City of Portland, Maine - Building or Use Permit Application

Permit No: 02-0236	Issue Date: MAR 25 2002	CBL: 388 H001001
-----------------------	----------------------------	---------------------

Location of Construction: 52 Abby Ln	Owner Name: Knop David T & Alisa J Its	Owner Address: 52 Abby Ln	Phone: 207-797-5465
Business Name: n/a	Contractor Name: Atlantic Pool	Contractor Address: 7 Union St. Biddeford	Phone: 2072841505
Lessee/Buyer's Name n/a	Phone: n/a	Permit Type: Swimming Pools	Zone: R-2

Past Use: Single Family	Proposed Use: Single Family / Install 30' round above ground pool.	Permit Fee: \$37.00	Cost of Work: \$1,100.00	CEO District: 2
Proposed Project Description: Install 30' above ground pool		FIRE DEPT: <input type="checkbox"/> Approved <input type="checkbox"/> Denied		INSPECTION: Use Group: R-3 Type: BOCA 1999 Signature: <i>J. Bowker</i>
		PEDESTRIAN ACTIVITIES DISTRICT (P.A.D.) Action: <input type="checkbox"/> Approved <input type="checkbox"/> Approved w/Conditions <input type="checkbox"/> Denied Signature: _____ Date: _____

PLOT PLAN FOR 30' ROUND
 ABOVE-GROUND POOL AT
 52 ABBY LANE PORTLAND

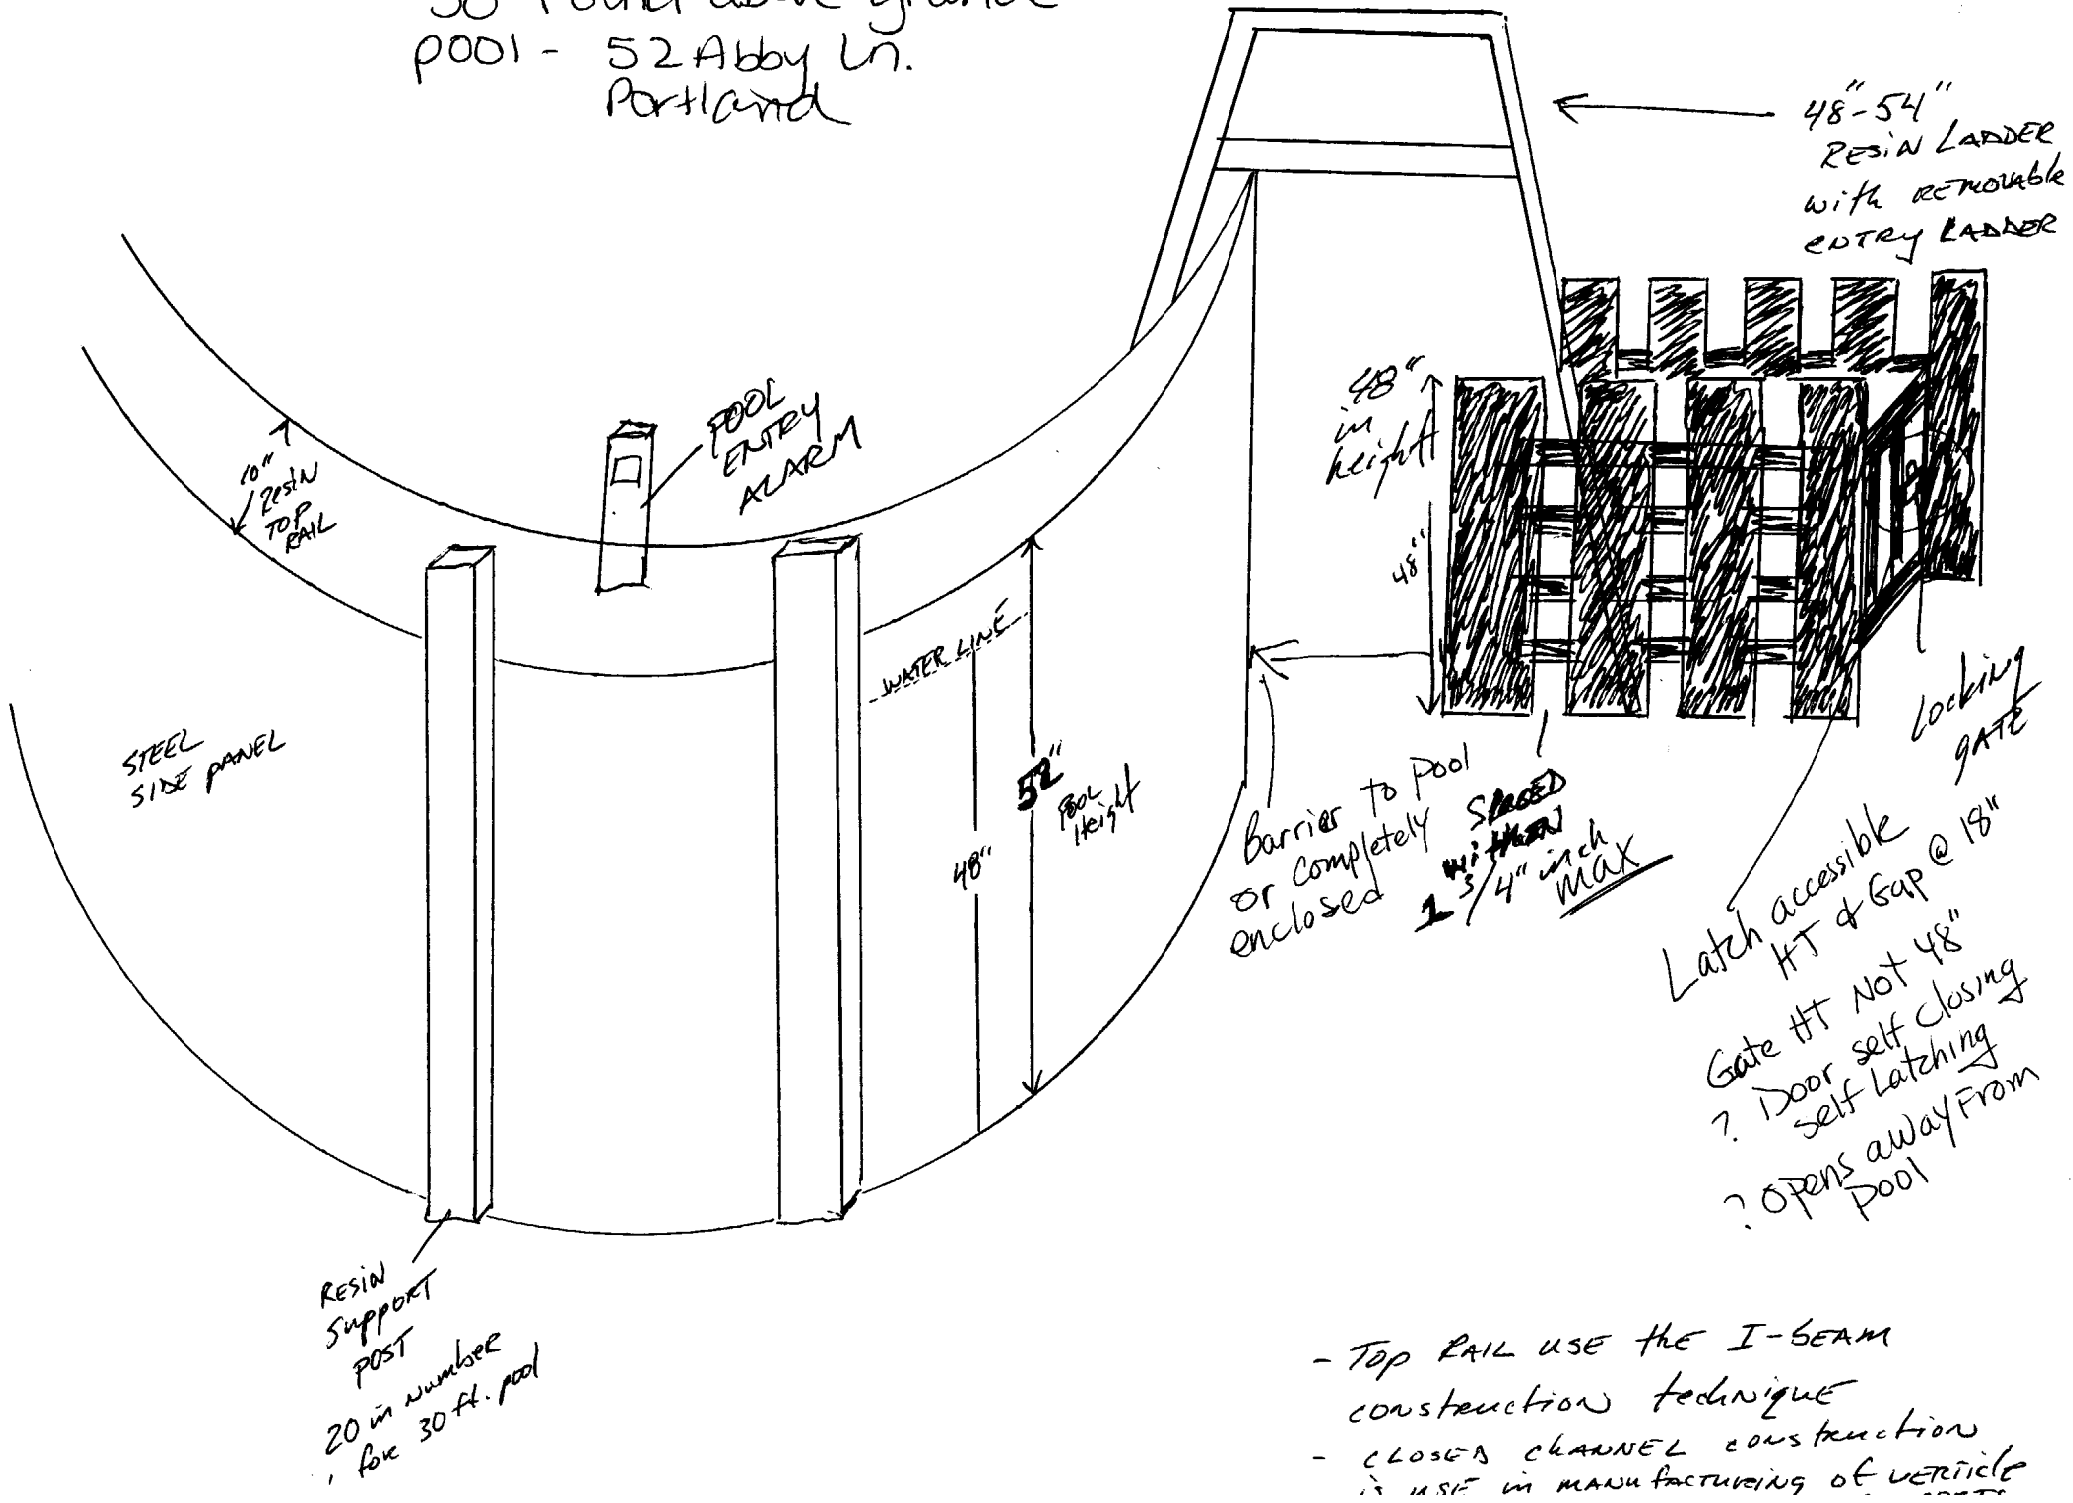
Please note that your pool is closer than 10 feet to your exterior deck. This deck could be in structural jeopardy if this pool were to fail. The Zoning Ordinance requires a 10 foot setback to principal structures (your main living structure). Please take care to protect your accessory deck.

Building Plan
 30' round above-ground
 pool - 52 Abby Ln.
 Portland

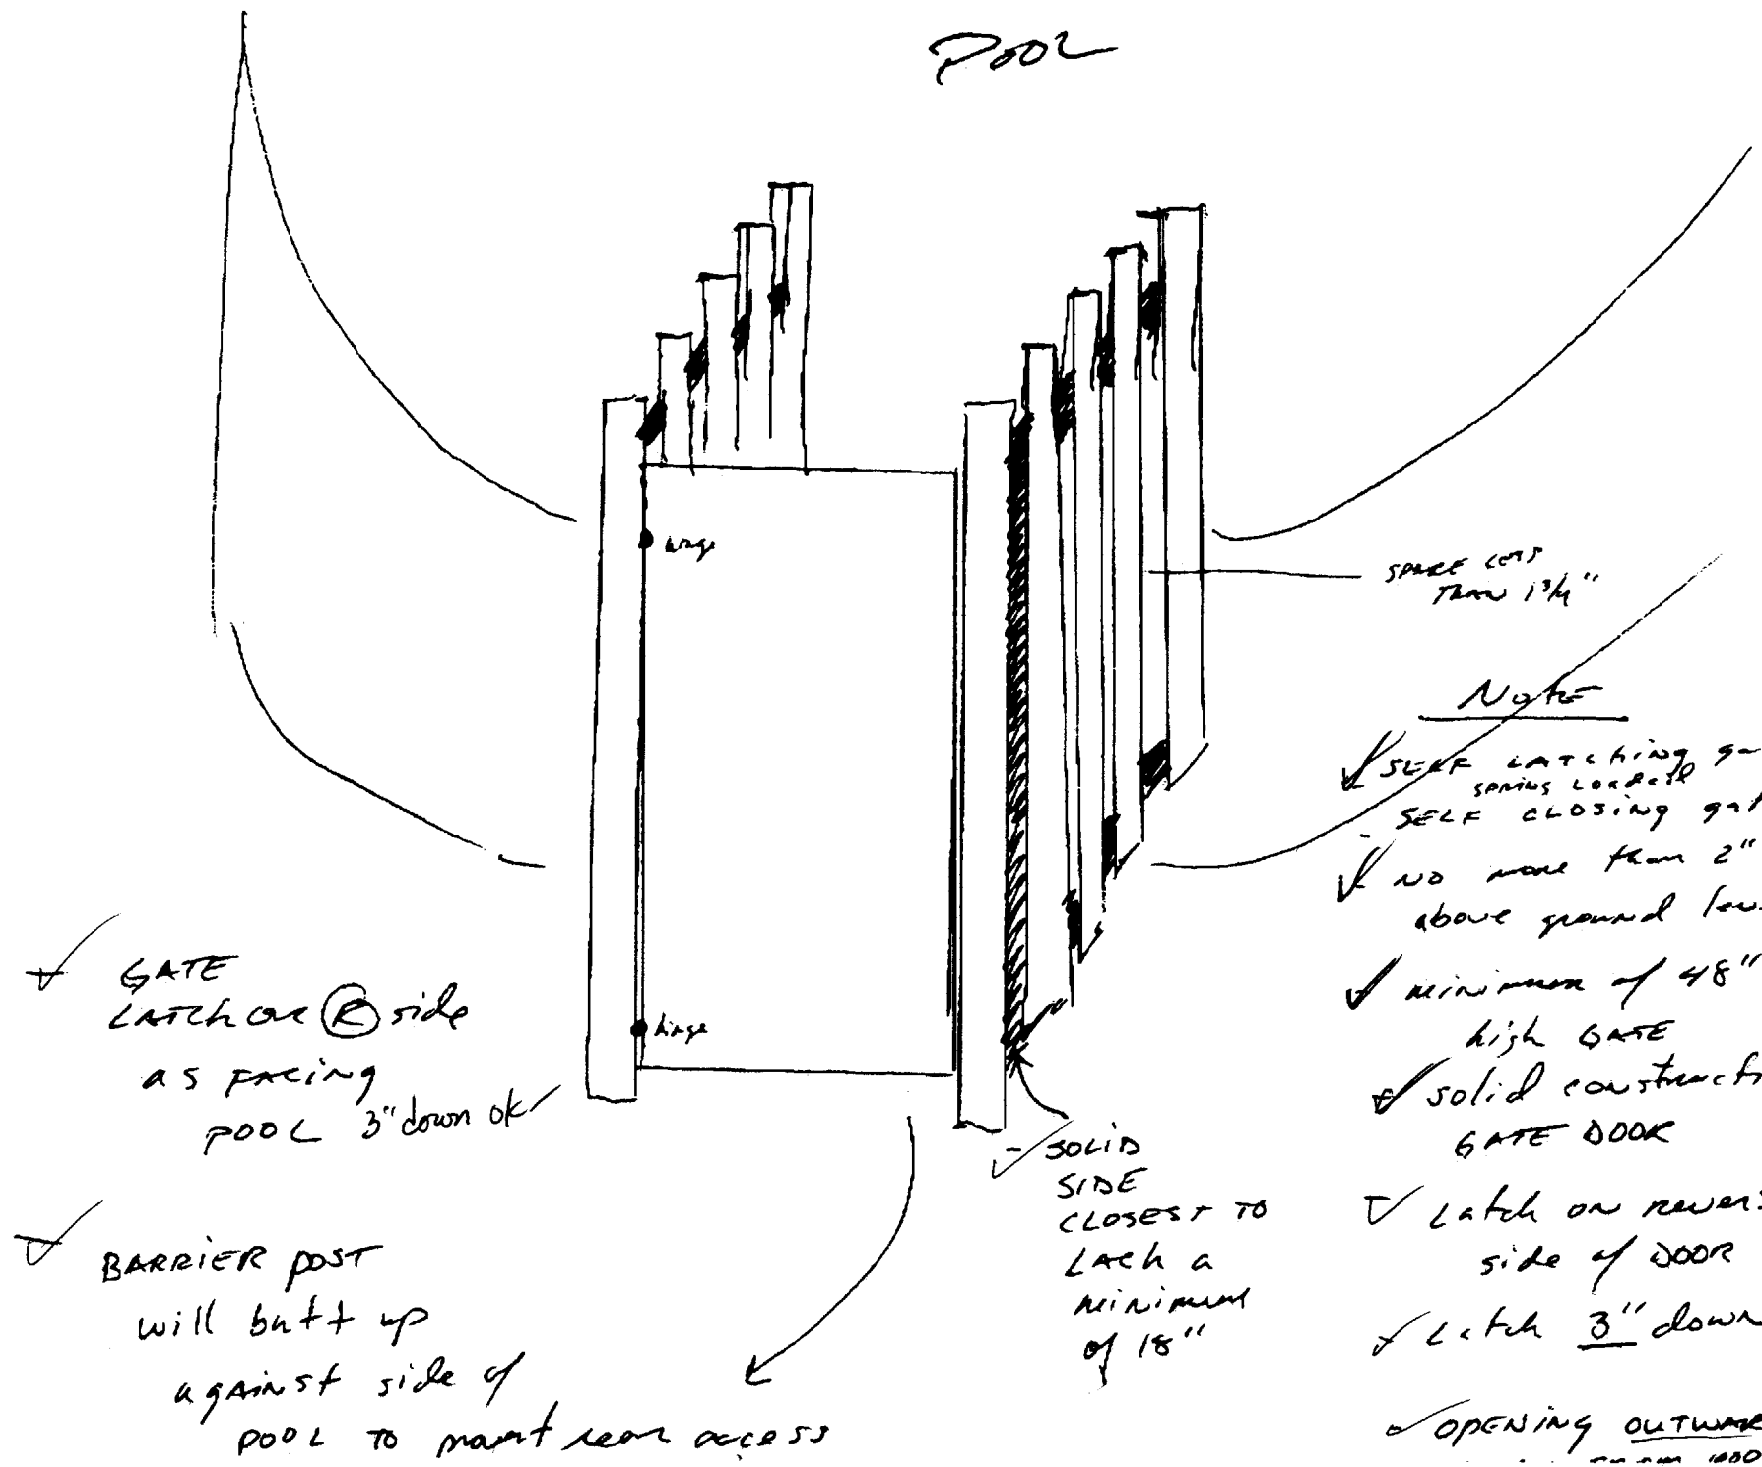
3/20/02 left message w/ Applicant to call concerning code issues JB

3/20/02 Mr. Knopf called - reviewed code requirements - he will submit changes. JB

3/21/02 submittal addressing code issues ok to approve. JB
